Project Title: American Toyota Building Permit #: _____ City Drainage #: C18d012
DRB#: _____ EPC#: _____ Work Order#: _____
Legal Description: Tracts A1 and B-1, American Toyota and lots 15-18 tract a unit b NAA
City Address: 5995 Alameda NE

**RE: Revised Grading Plan (C18-D012)
HLP Endodontics
Albuquerque, New Mexico**

RE: American Toyota (File: C18D012)
Drainage Report, Engineer's Stamp Date 3-16-15
Grading and Drainage Plan, Engineer's Stamp Date 3-17-15

ENGINEER'S SEAL 	AMERICAN TOYOTA		DRAWN BY WCWJ
	GRADING AND DRAINAGE PLAN		DATE 3-27-15
 1606 CENTRAL AVENUE SE SUITE 201 ALBUQUERQUE, NM 87106 (505) 872-0999	SHEET #		21403-LAYOUT-1-25-14
	JOB #		21403

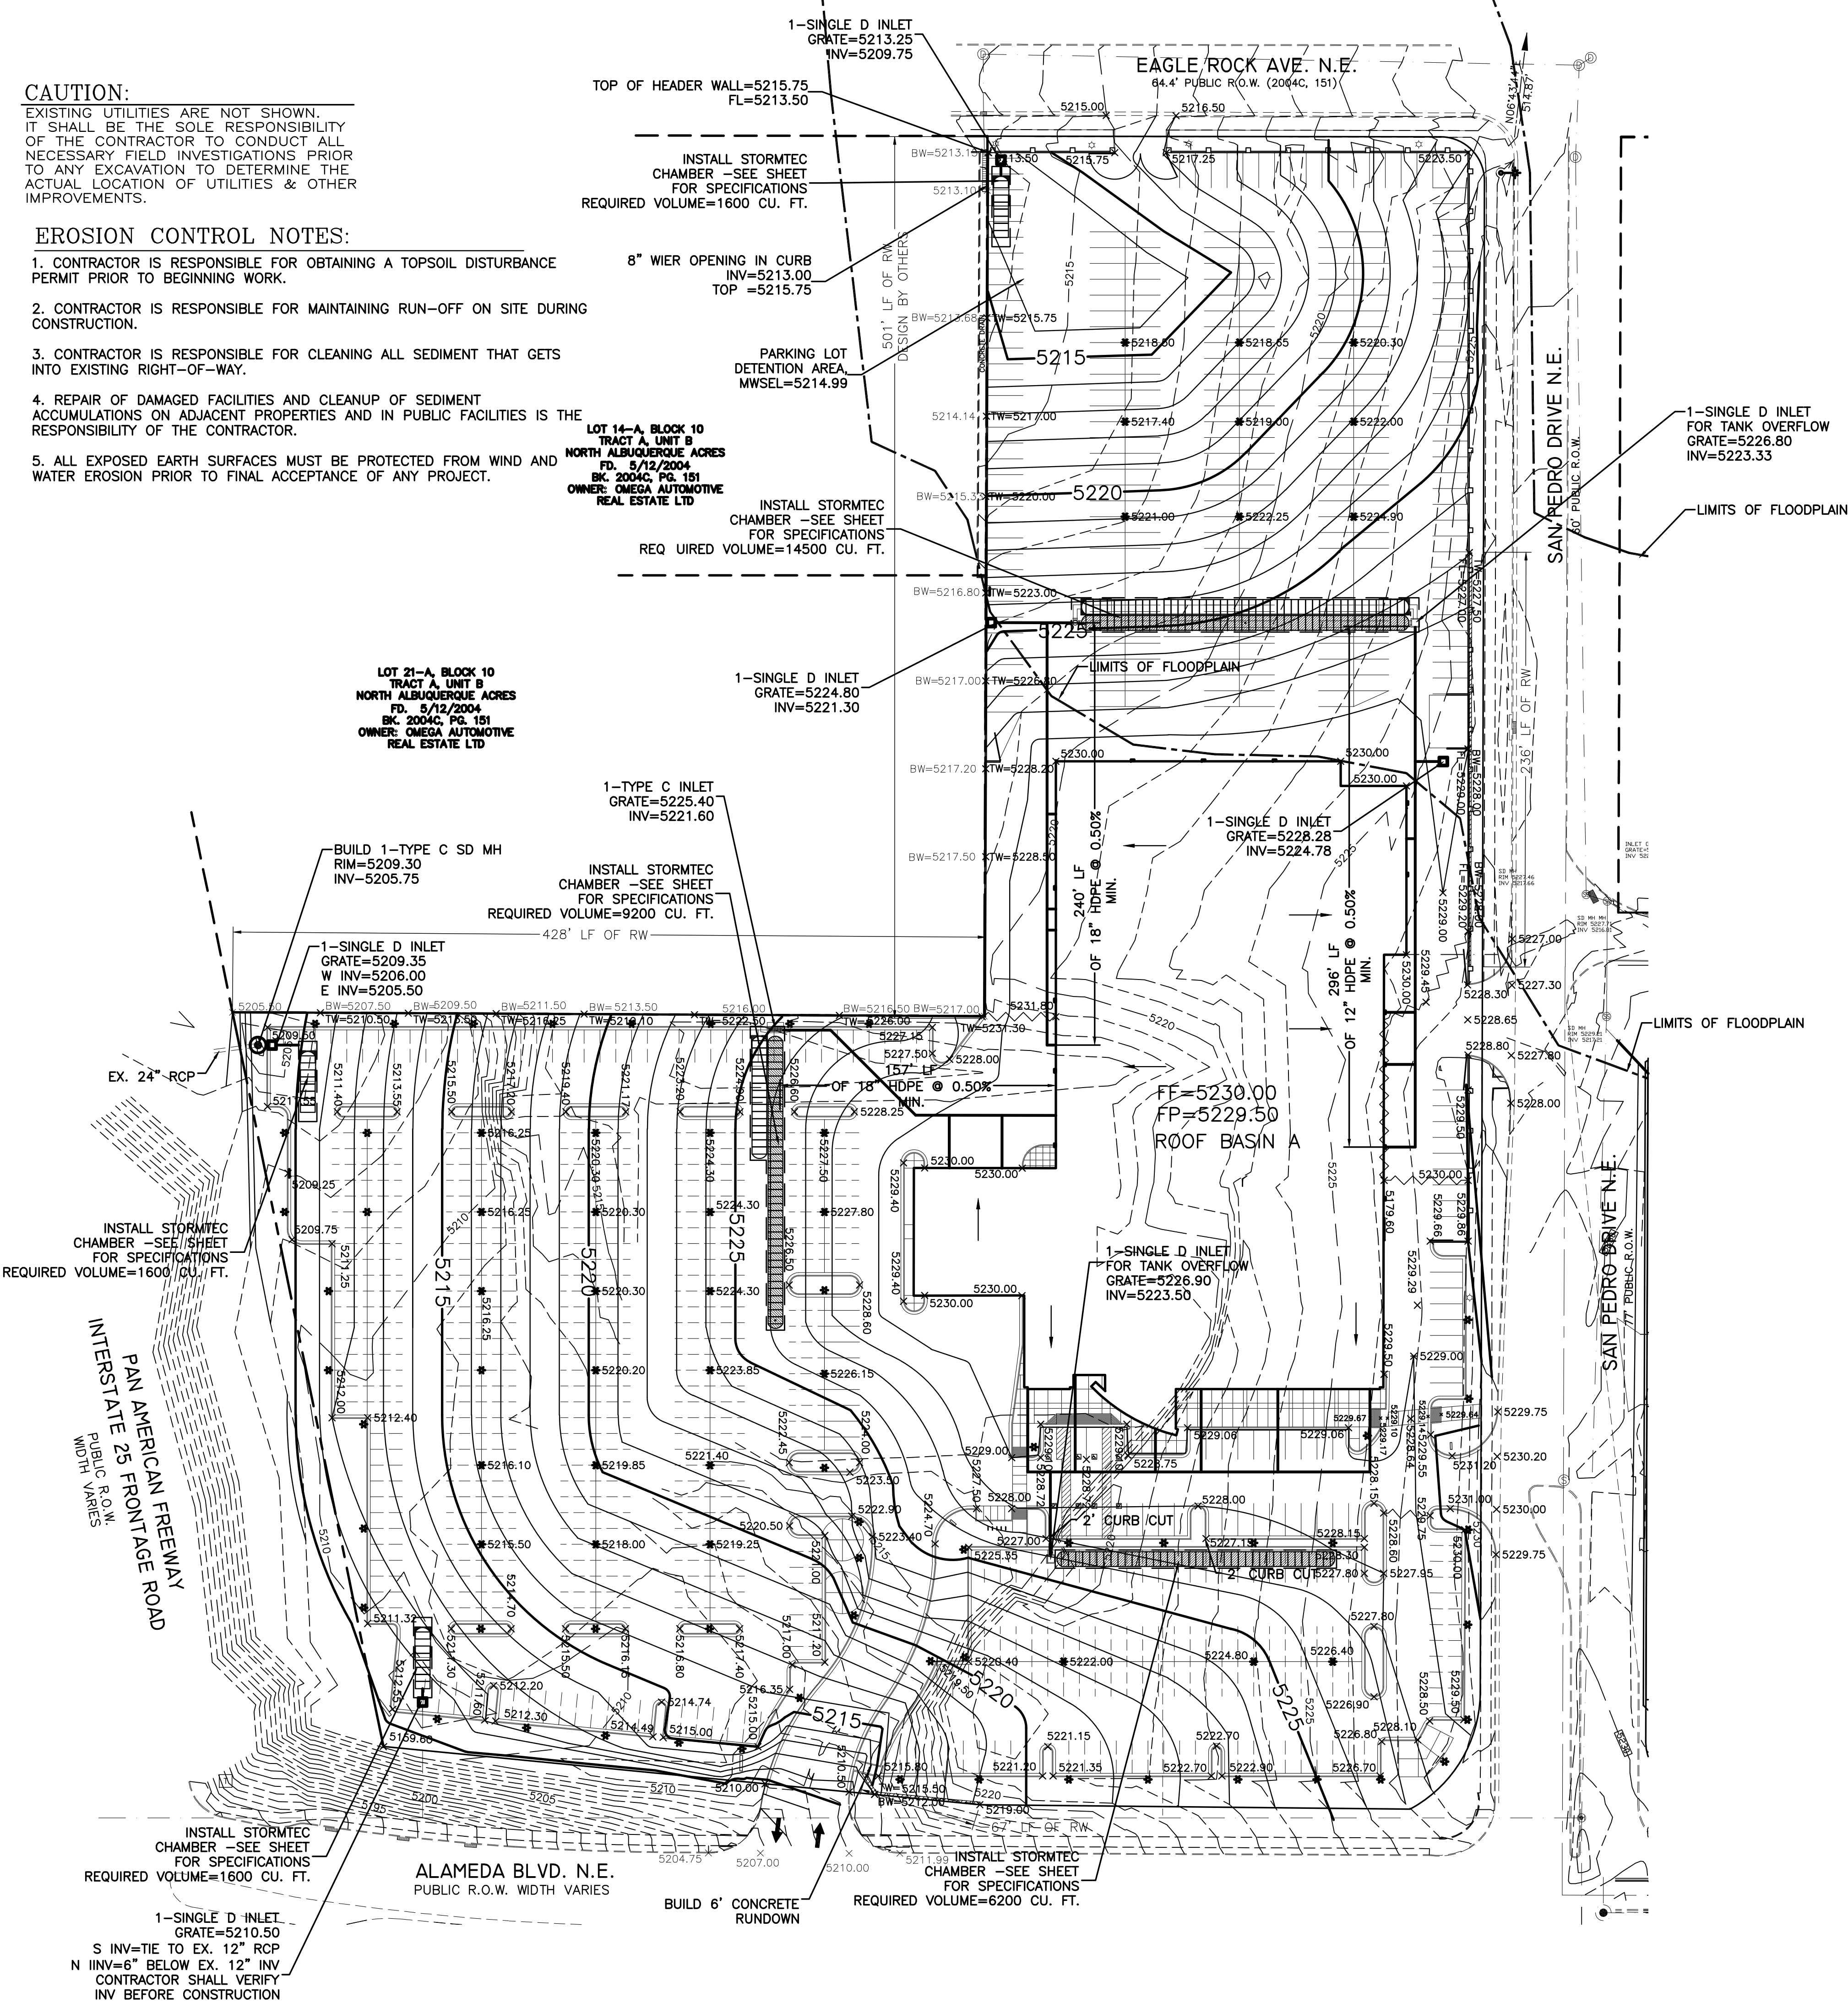
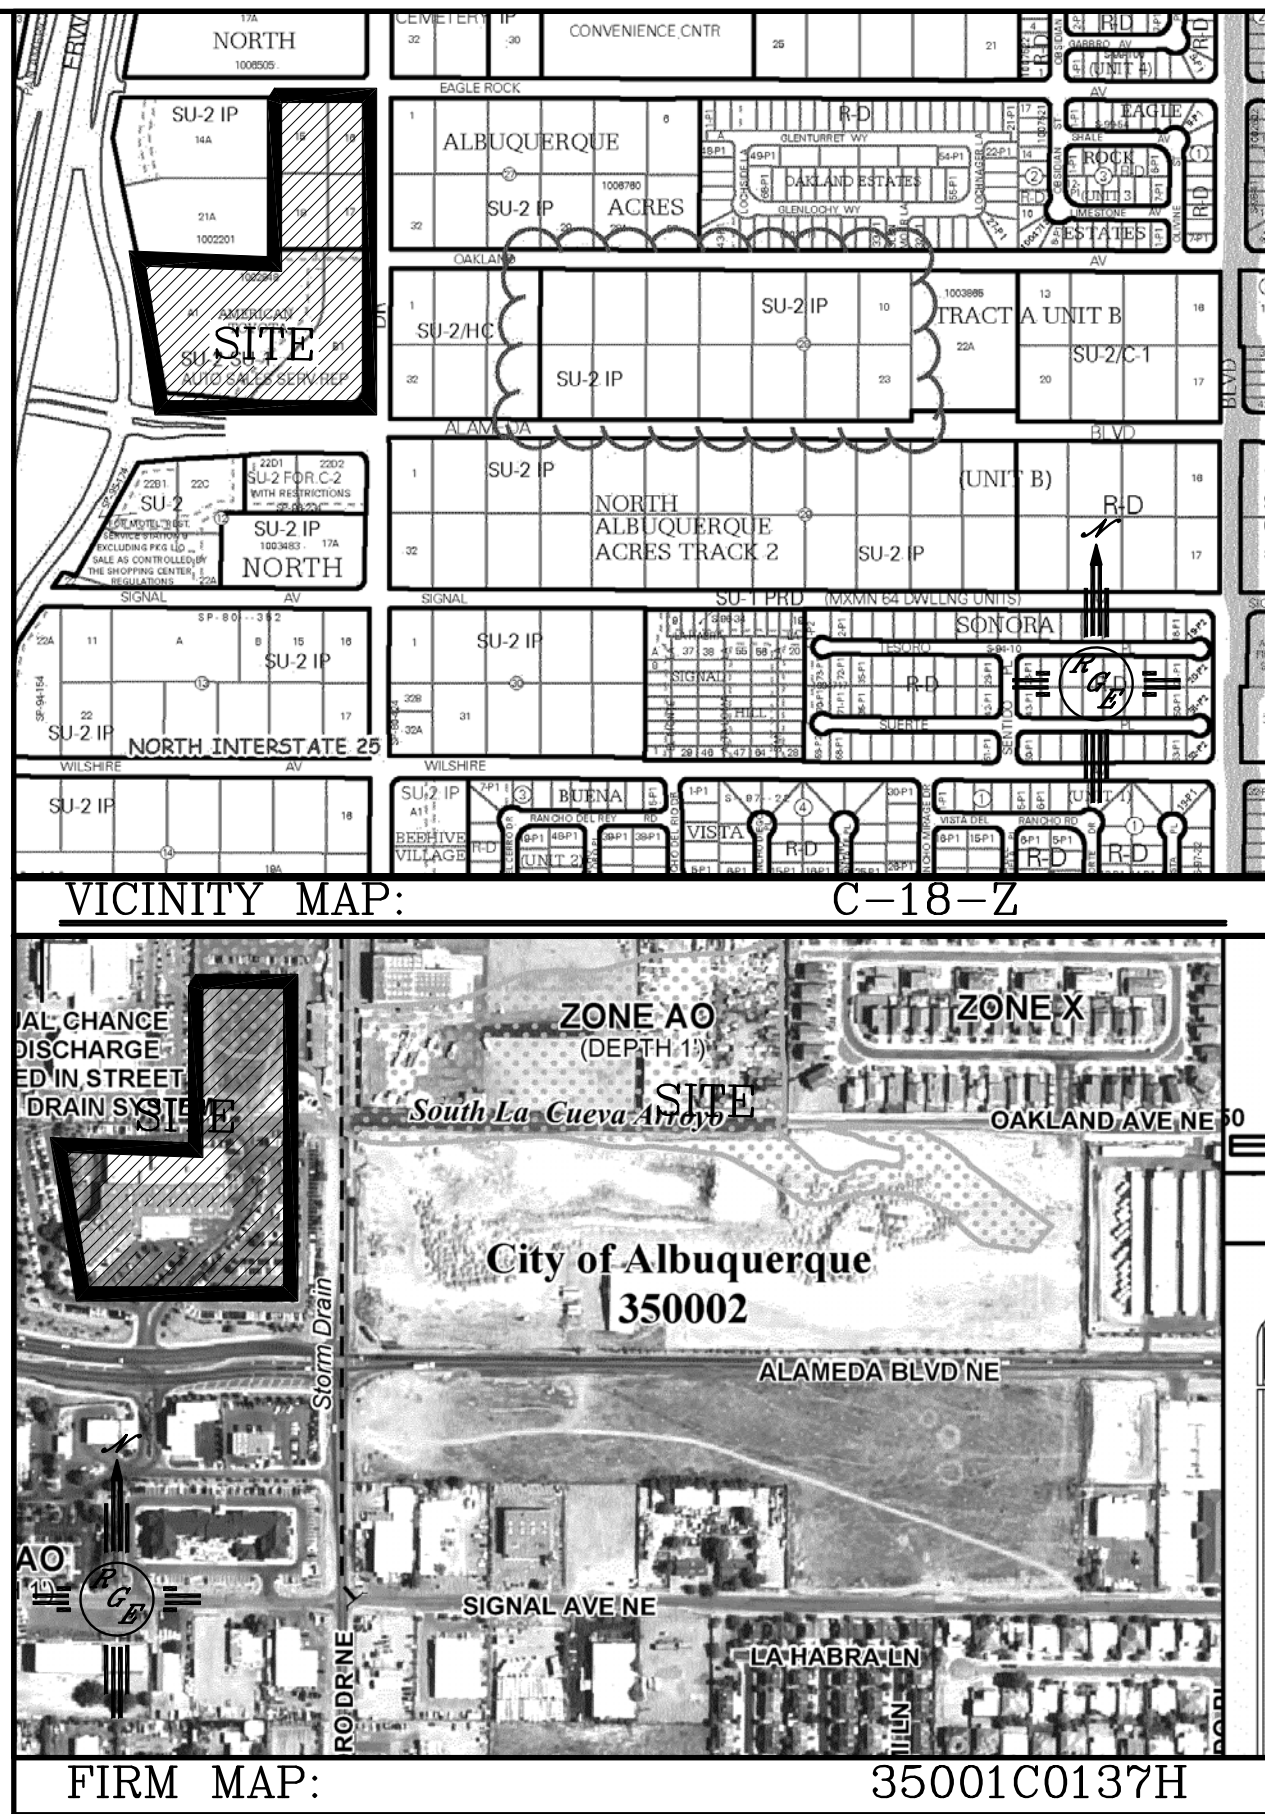
1. Proposed runoff limited to 25 cfs

2. Add first flush capture at outfalls 2,3,4

3. Detail how first flush mechanism works

1. The proposed runoff to the Alameda Storm Drain is limited to 25 cfs. This is based on trying to reconcile the difference between the existing runoff of 33 cfs and the allowed runoff of 16 cfs from SAD #201(though this site is not a part of the hydrology report).
2. The "first flush" needs to be captured at Outfalls 2,3, and 4.
3. Details showing how the "first flush" mechanism will work need to be shown prior to approval for Building Permit.

The grading plan as approved for site plan approval shows 25.5 cfs. The addition of the 3200 cubic feet of additional water quality tanks at the out falls will reduce the flow to below 25 cfs

We have added 1600 cubic feet harvest chambers at each outfall. The water harvest from this site contains all the work area and exceeds the required volume.

We have an inlet and holding tank just before the outfall. The inlet captures all the flow until the tanks are filled then the water passes over inlet to outfall
